Outer Dowsing Offshore Wind

Response to Section 51 Advice

Schedule of Changes for Plans

Document Reference: 2.0

2.2 Offshore Works Plans

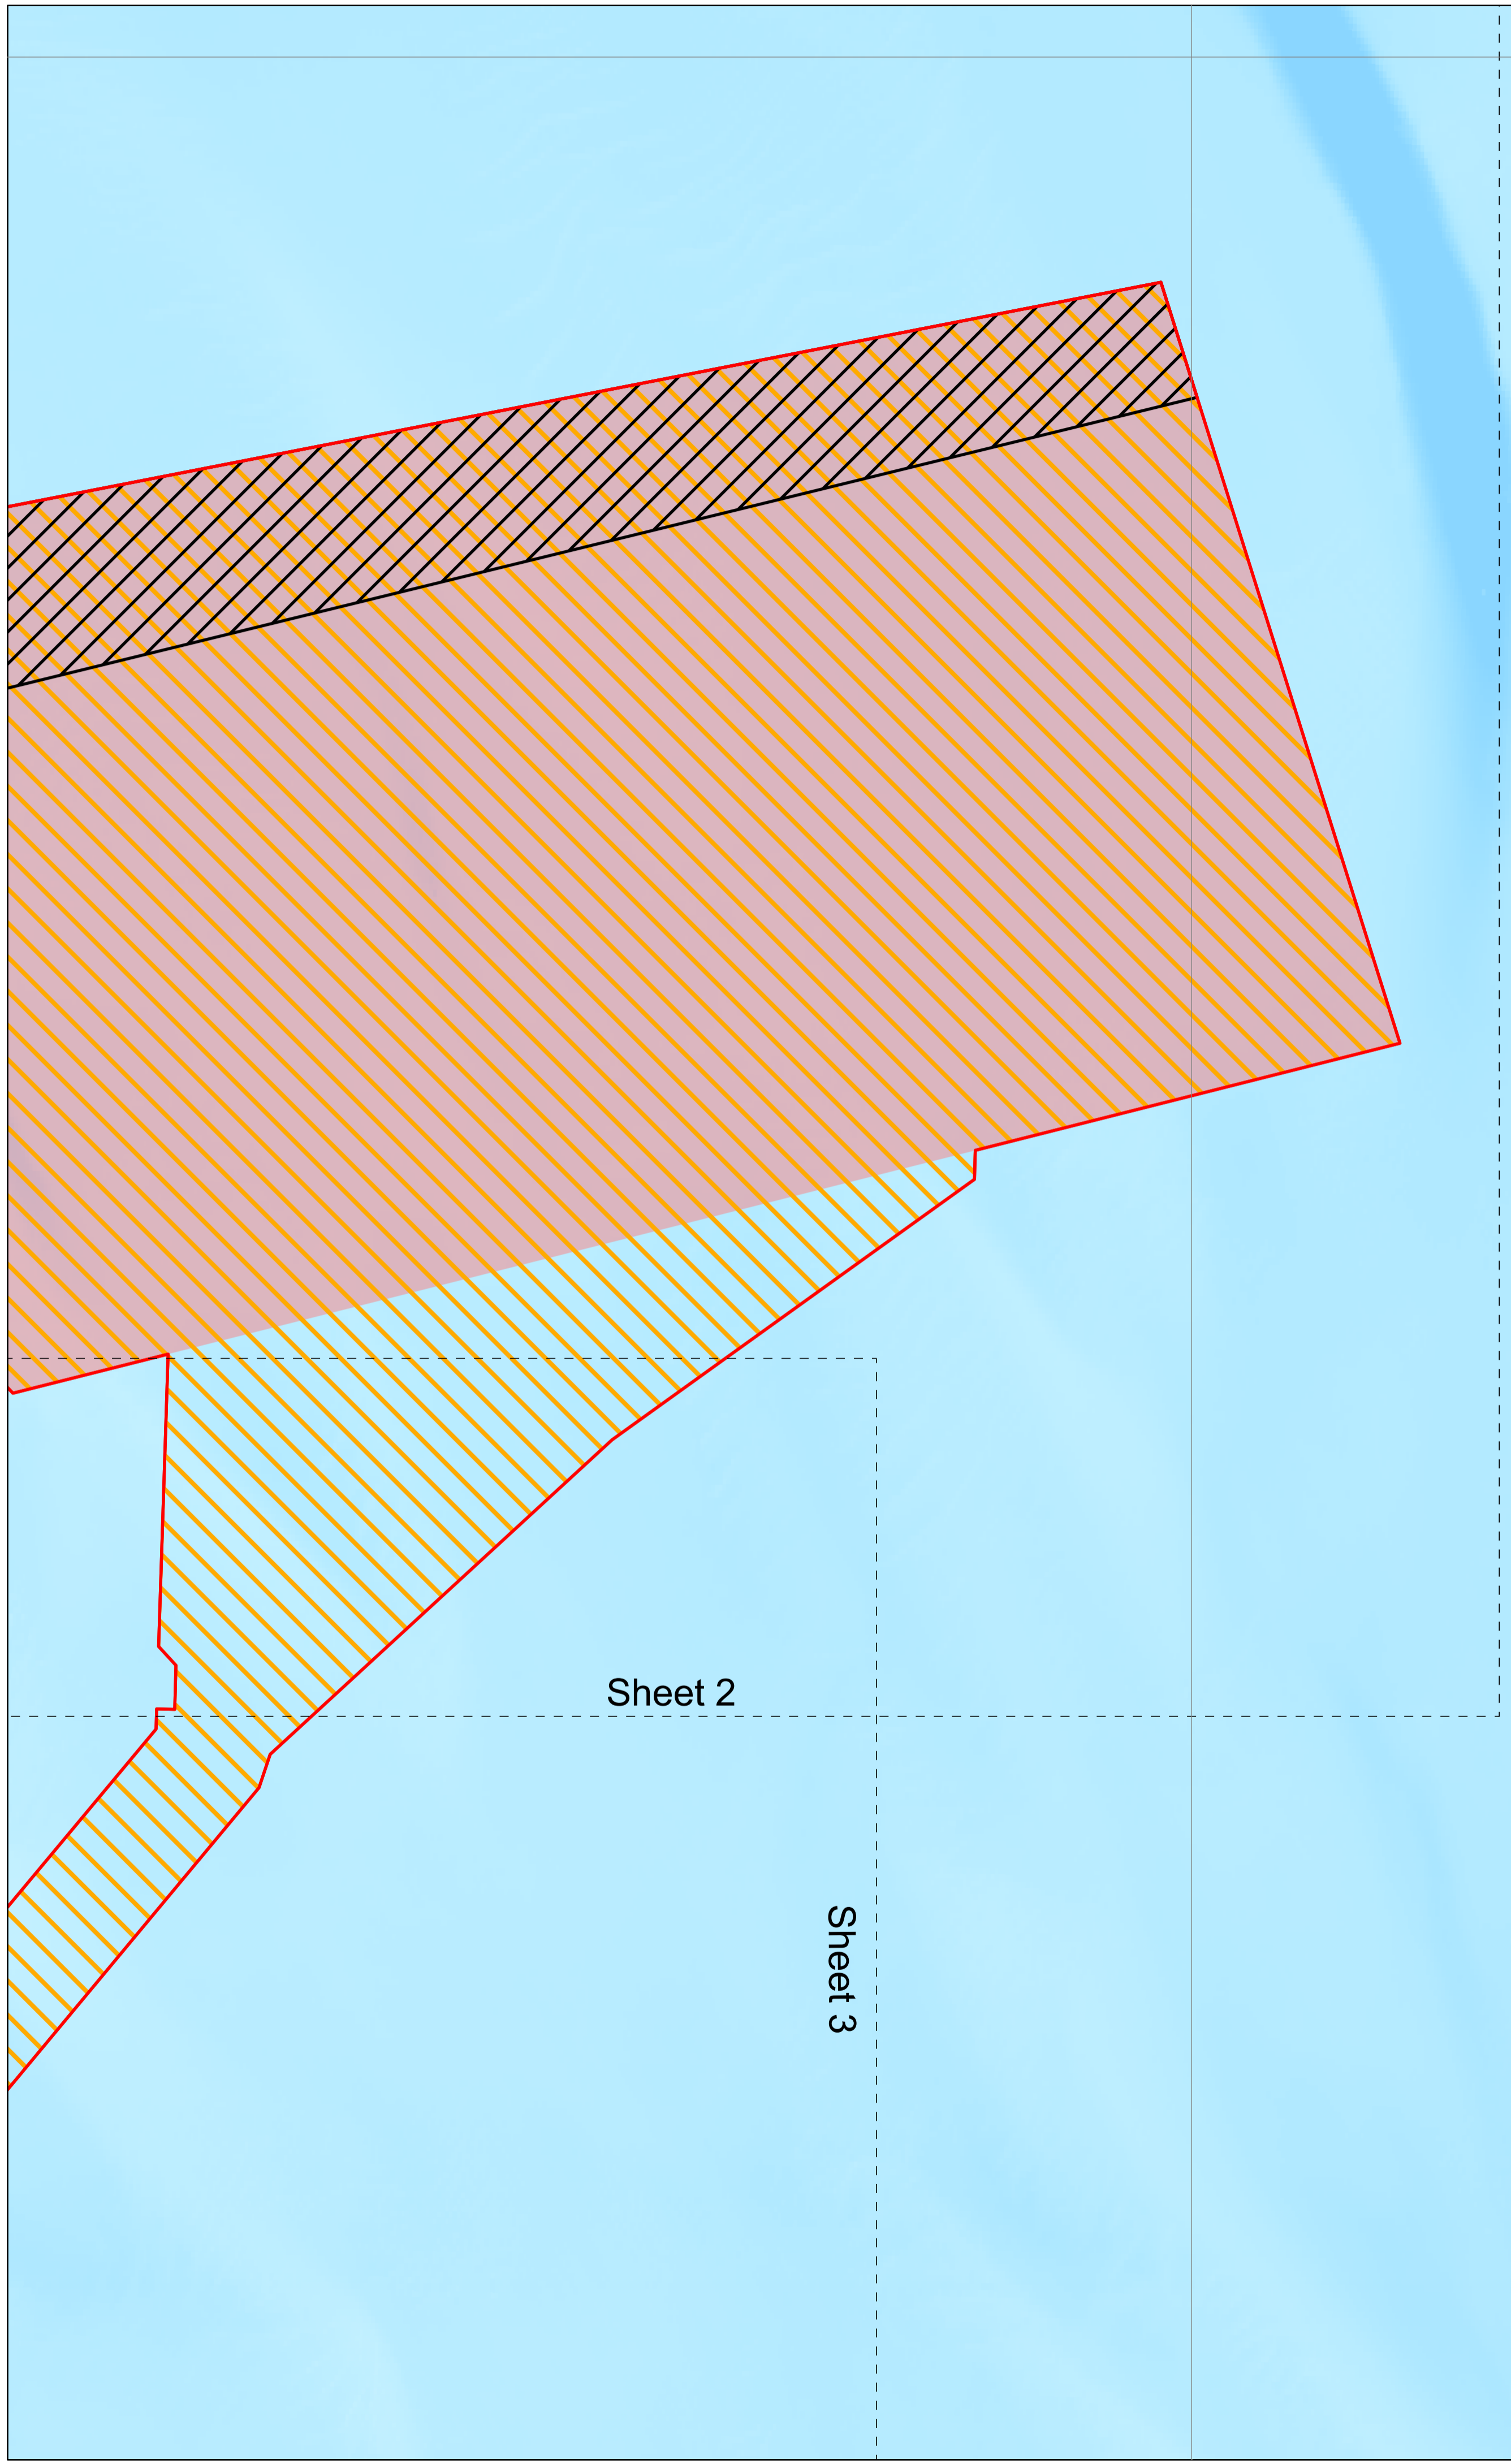
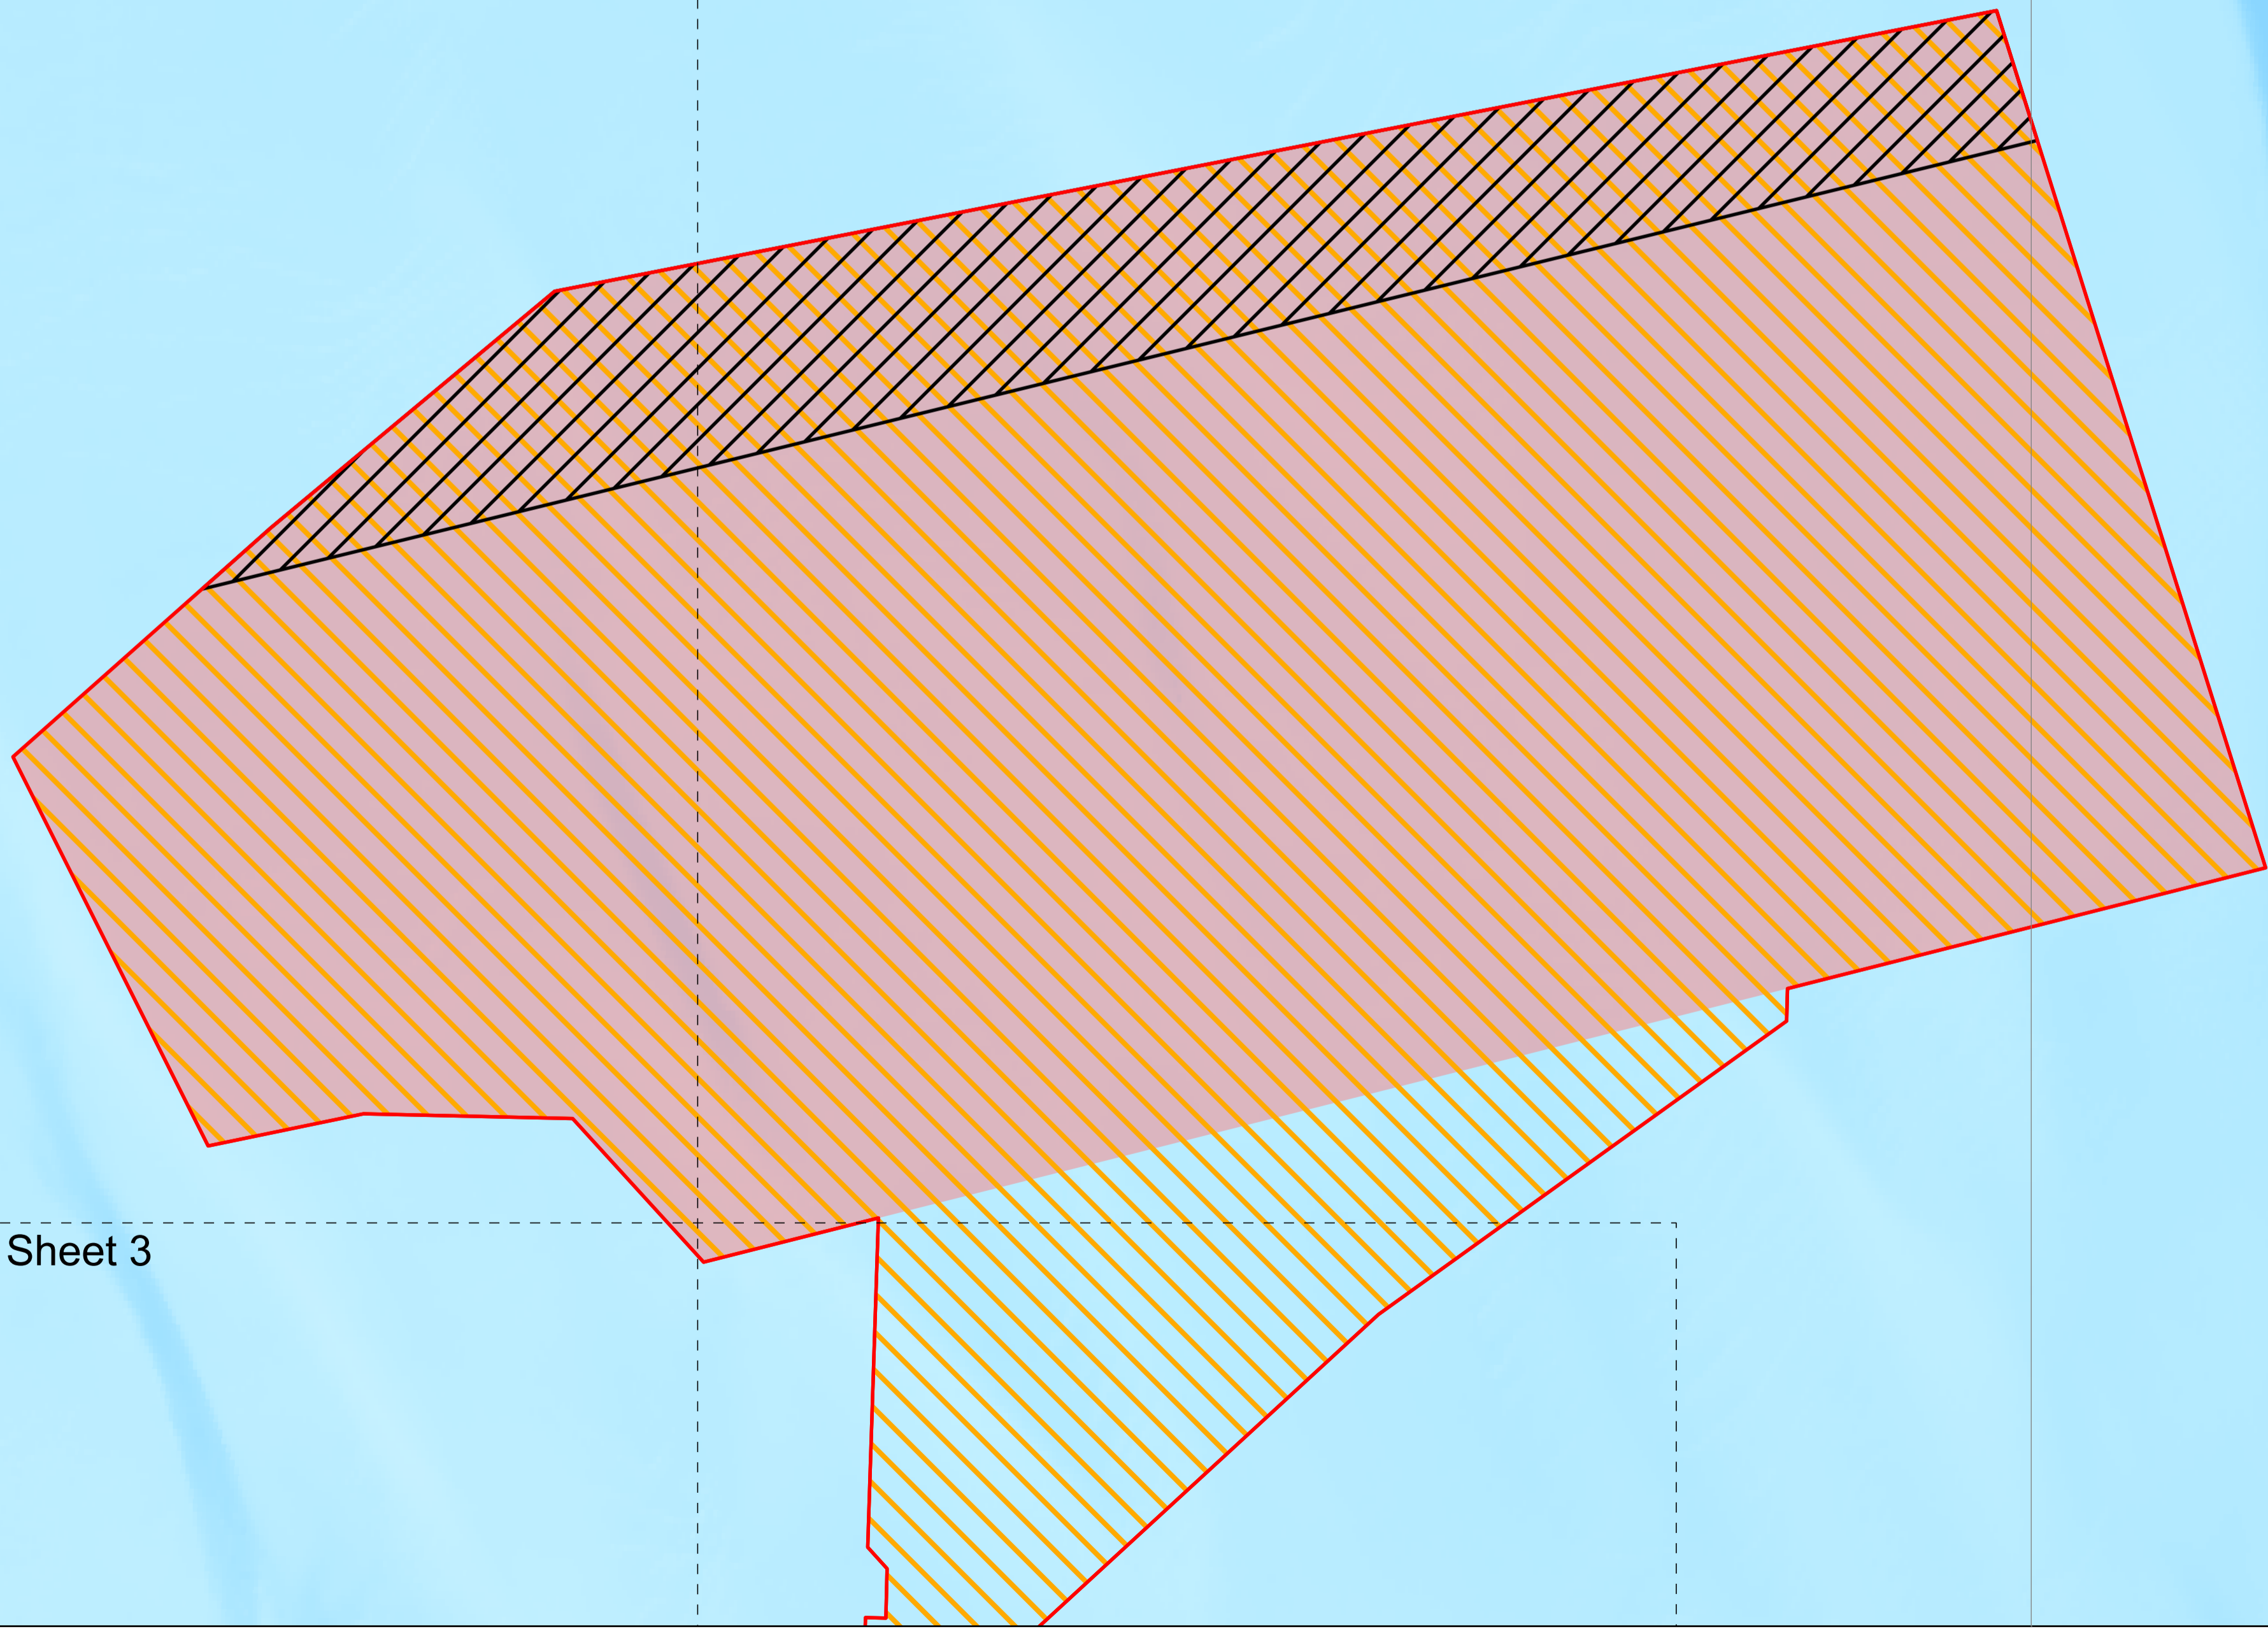
| Plan Numbers | Reference | Plot Number(s) if appropriate | Date of Change | Revision Change | Change Made | Reasons for Change |
|--------------|-----------|-------------------------------|----------------|-----------------|---|--|
| 2.2 | | N/A | July 2024 | V2 | Updated to reflect refined Order Limits | Updated Order Limits due to updated MHWS/MLWS datasets |
| 2.2 | | N/A | July 2024 | V2 | Amended works descriptions to better align with the DCO | Section 51 Advice request to align key text with the draft DCO works descriptions. |
